From: Simon Davis
Sent: 09 April 2021 15:50
To: 'Myles'
Subject: RE: Planning Ref: BR/81/21/CLE

On the subject of the number of people, as I understand it, you have applied for a Certificate because you propose to go from the current class C3 dwelling use to a class C4 House in Multiple Occupation (HMO) and this is permitted development. However, class C4 only allows for a HMO occupied by 6 people. Therefore, despite there being only 6 bedrooms in the property, any proposal to have more than 6 people within the HMO would not be permitted development. If this is what you are seeking then you would instead need to make a full planning application and I would advise that you withdraw the Certificate application s otherwise we will have to refuse it. If you want to withdraw please advise in writing.

Scale 1:75 @ A3

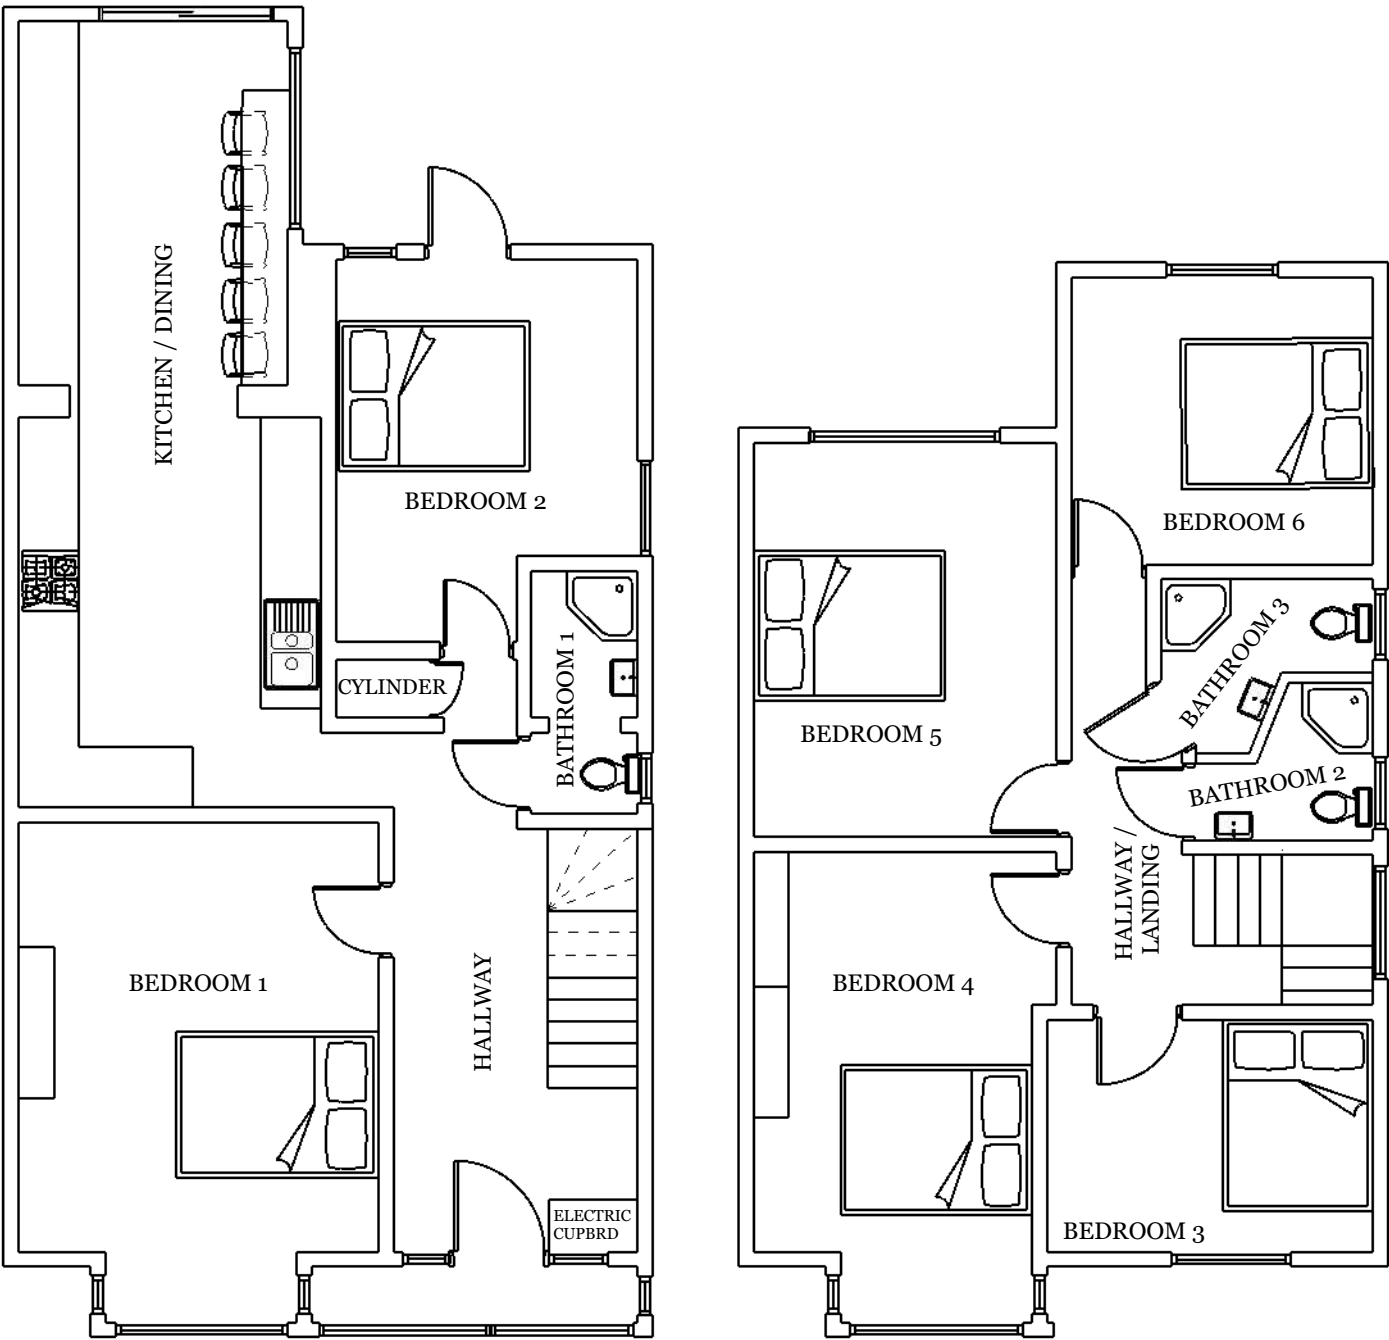
To correct the scale, the drawing would need to be re-drawn at a different scale – at say 1:50 or 1:100. This would then allow us to measure the rooms and work out the floor areas.

I am currently your case officer although this may yet be reallocated to an alternative officer. However, in the meantime, I have been contacted by our Environmental Health Officer (EHO) who has asked if you can confirm how many occupants you intends to have as tenants in this property please? We note that the application is for a 6 bedroom HMO but the floorplans also appear to show double beds in all rooms. The EHO also asks that you provide room sizes in m2.

Please also note that our system does not allow us to electronically scale from 1:75 plans. Those in the following screenshot are the only options we have. Would it be possible to provide a new floorplan in a different scale and then also annotate/provide a key with the room sizes.
